Tandridge District Council Principal Areas of Disagreement Summary Statement	Gatwick Airport Norther Runway Project Development Consent Order	Version: v1 Submitted: 20 th October 2023
---	---	---

Diagram 3.3.9: Model performance before and after adjustment, London zone

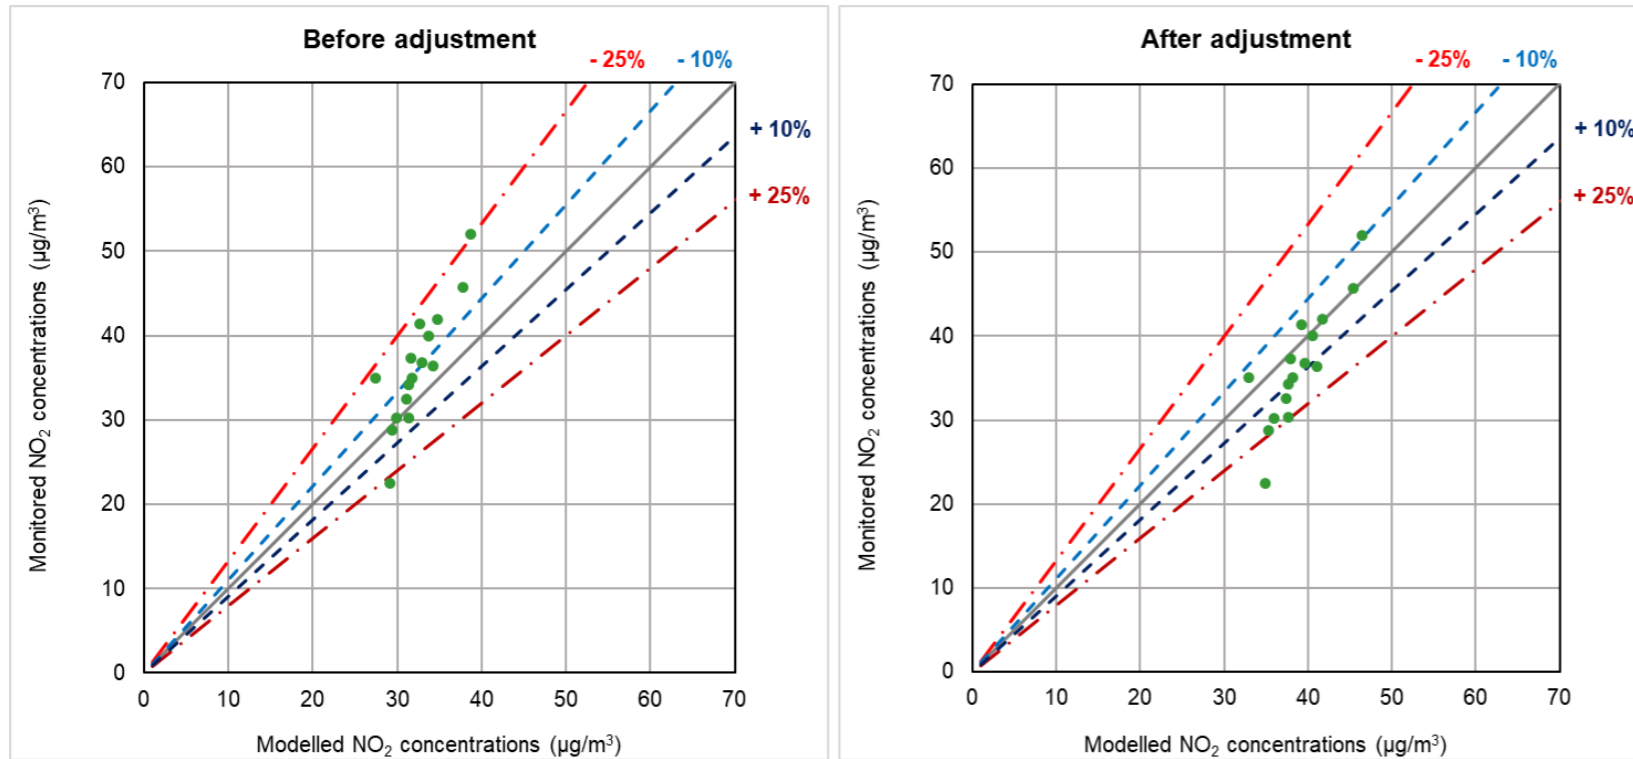
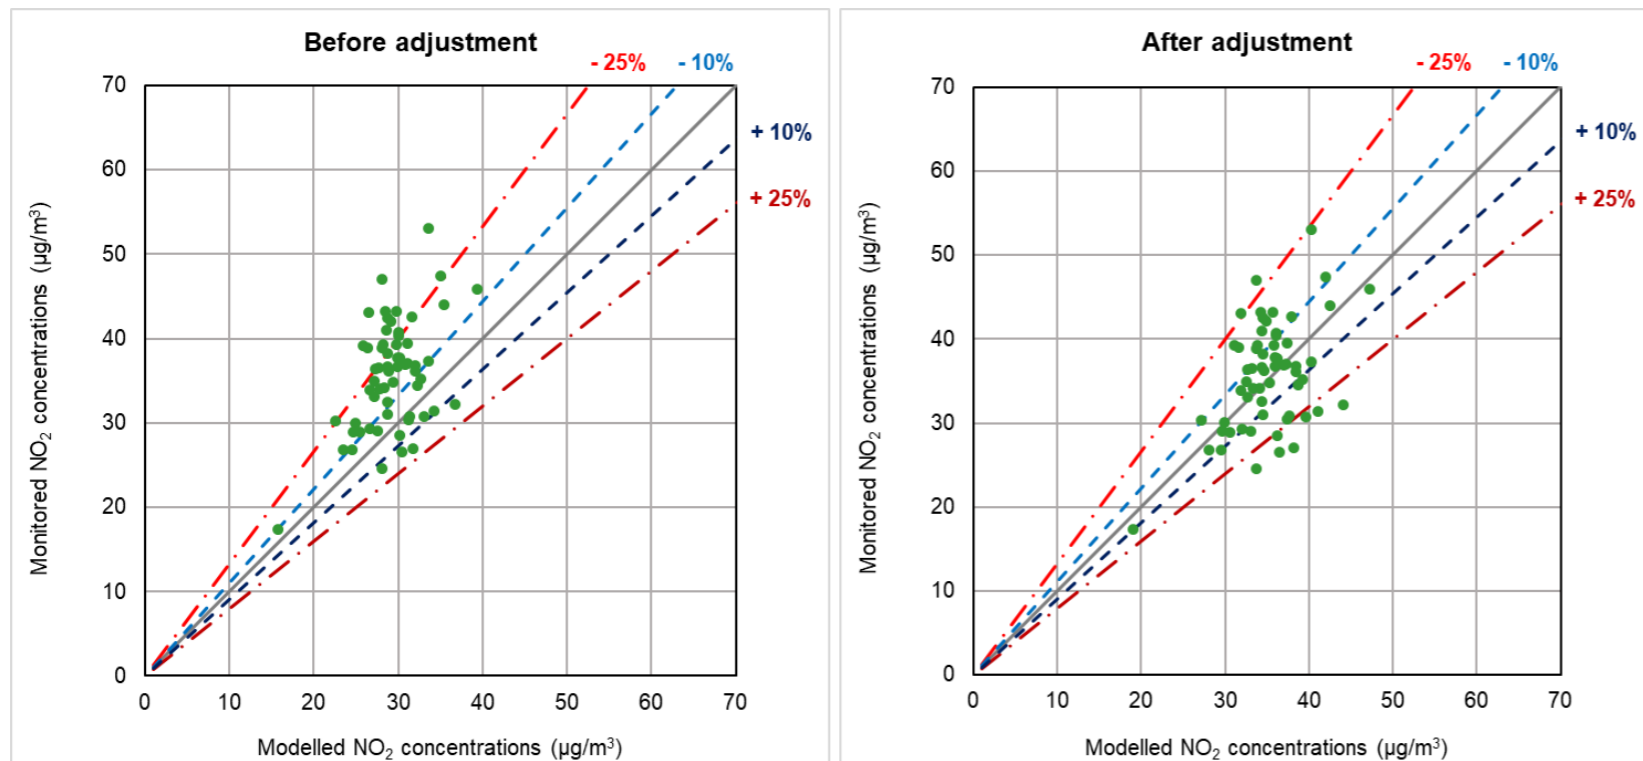
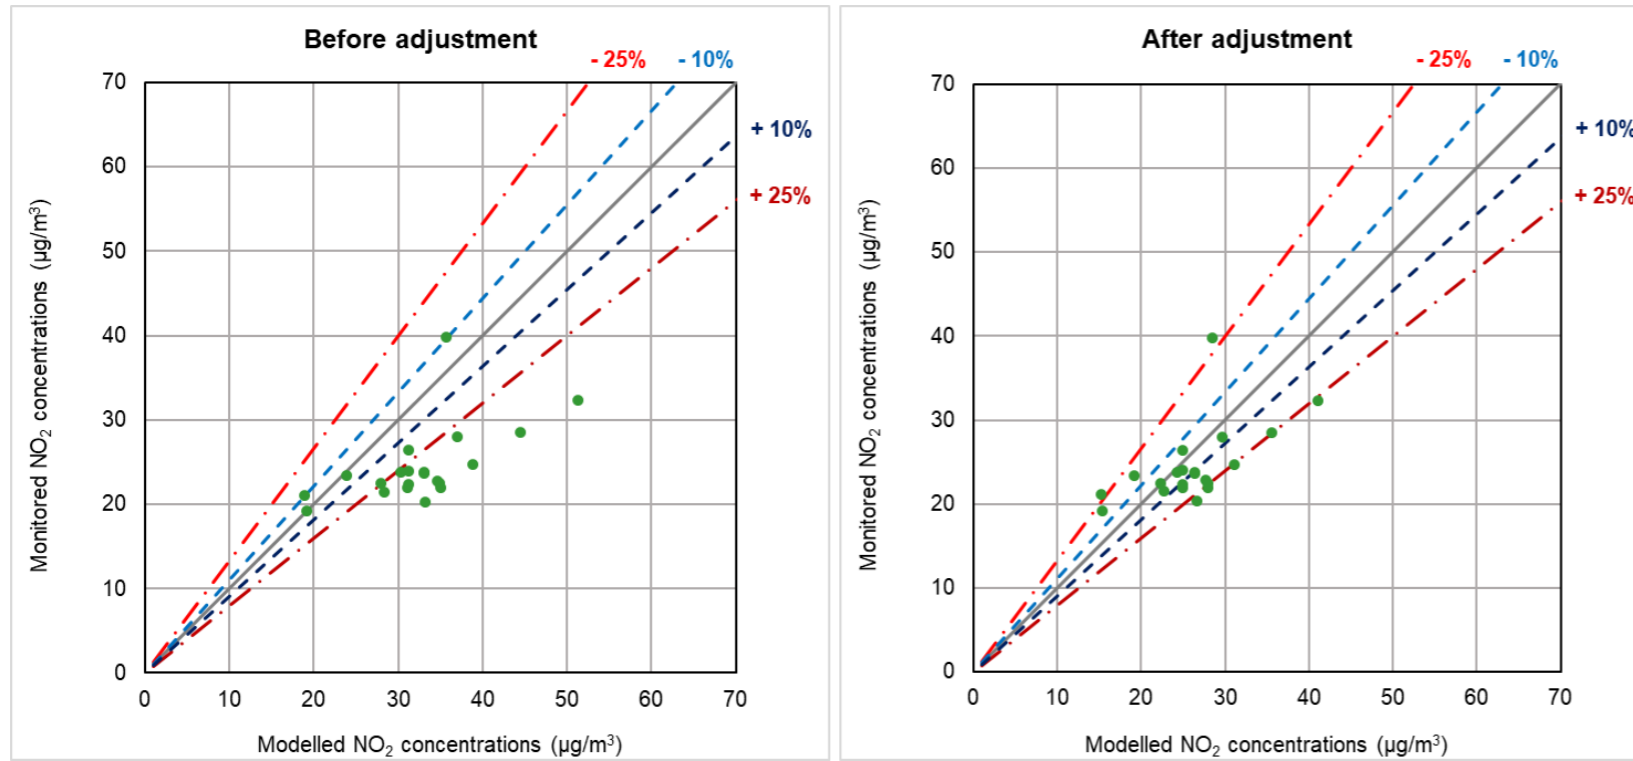
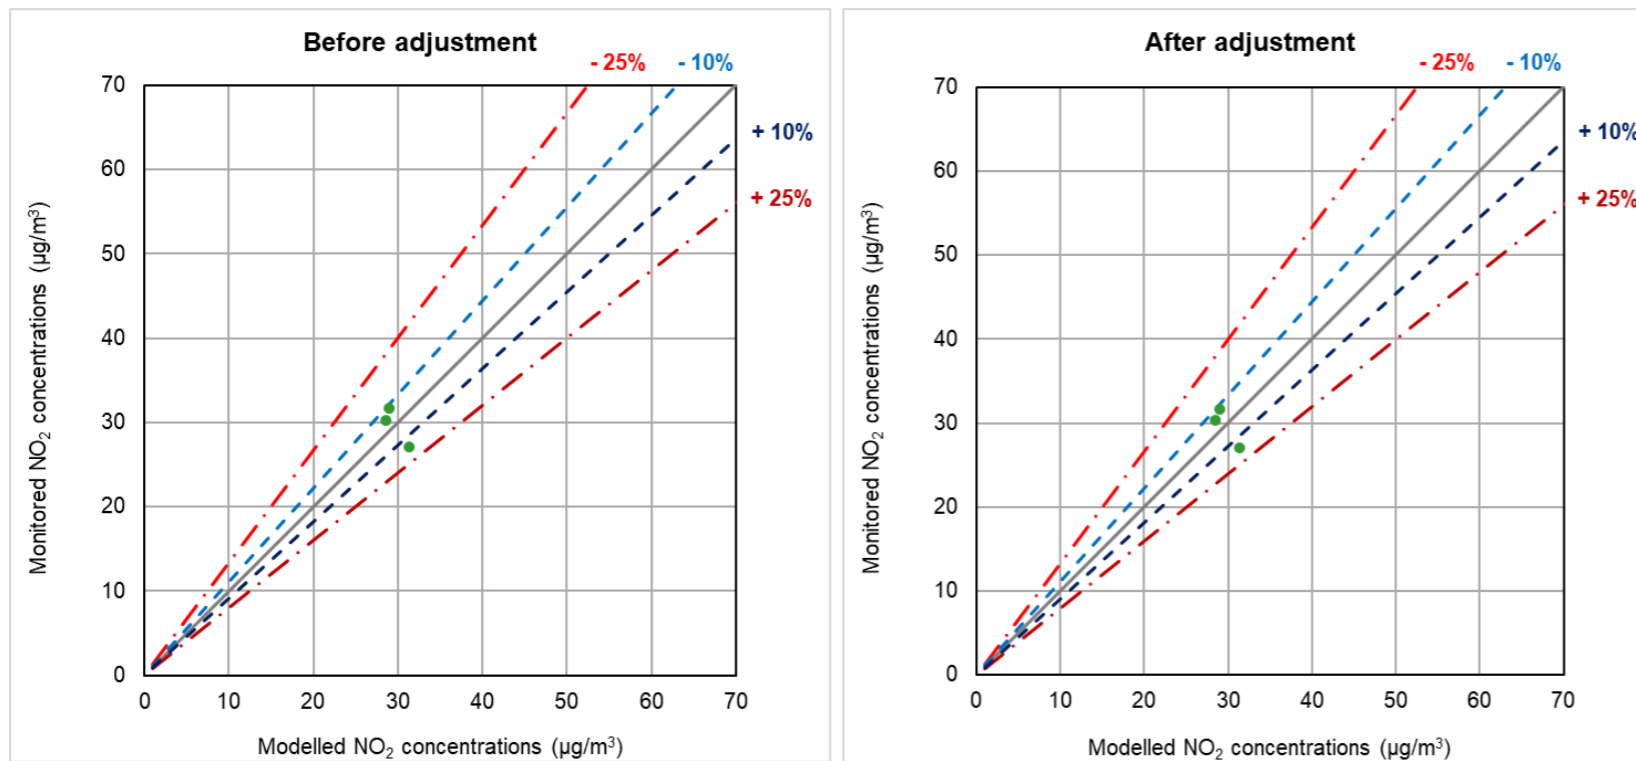
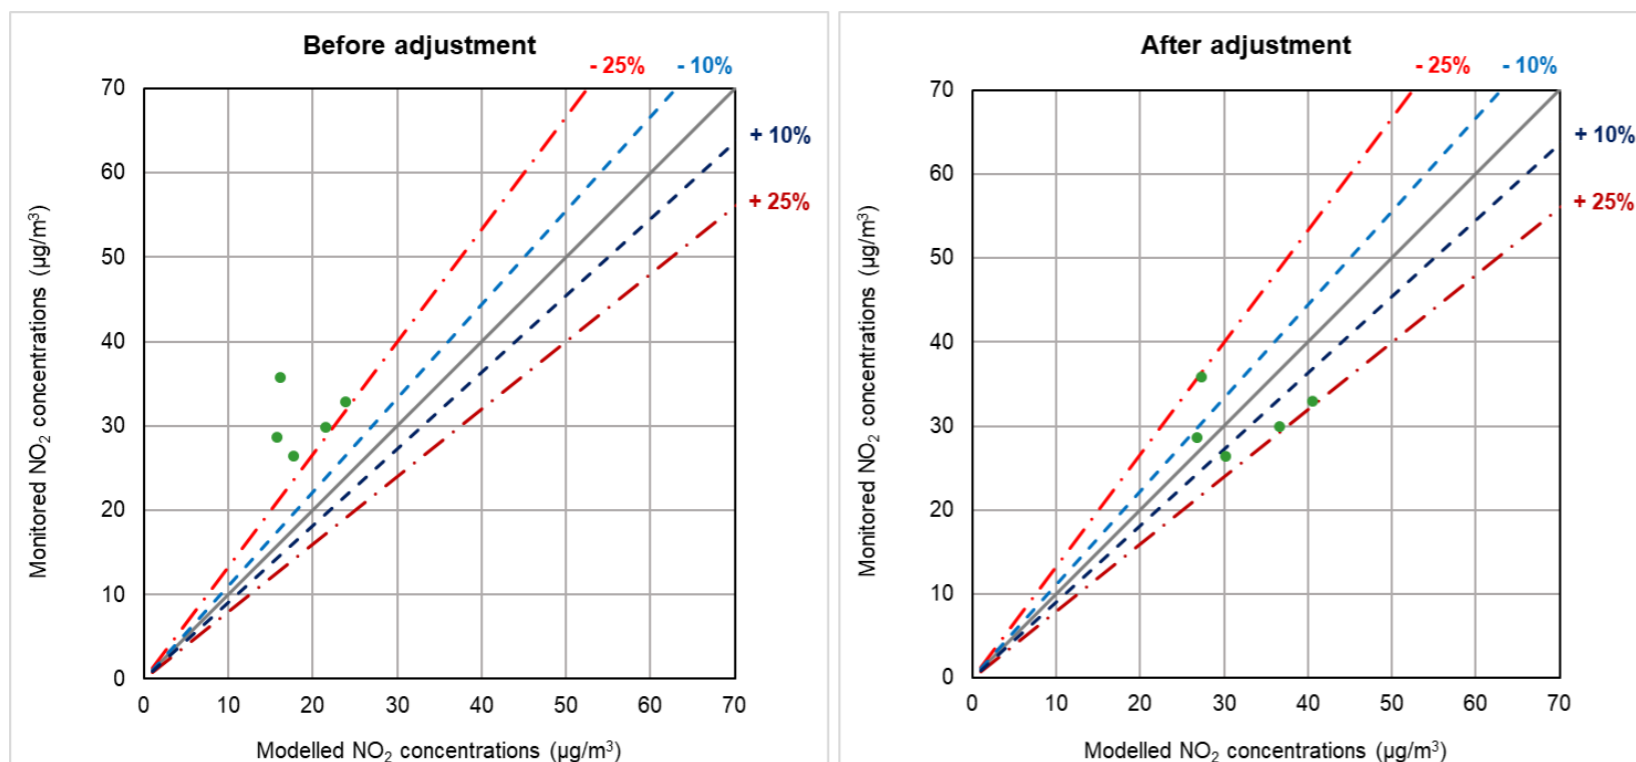
Principal Issue in question	Concern held	What needs to change/be amended/be included in order to satisfactorily address the concern	Likelihood of concern being addressed during Examination
AQ06: Monitoring sites	TDC is concerned that excessive numbers of monitoring sites may have been excluded from model verification which could have improved the quality of the air quality verification and so the confidence in outputs.	Further details on the sites excluded on this basis is required. Further details could be added to Table 3.2.2 of Environmental Statement Air Quality Appendix 13.6.1 to address the clarification points.	Uncertain
AQ07: Verification zones	TDC disagrees that enough justification was provided for the selection of different verification zones and why the model would be expected to perform differently in each area. A sensitivity test is required to demonstrate that the conclusions of the assessment would not change if a single verification factor were used.	A sensitivity test is required to demonstrate that the conclusions of the assessment would not change if a single verification factor were used.	Uncertain
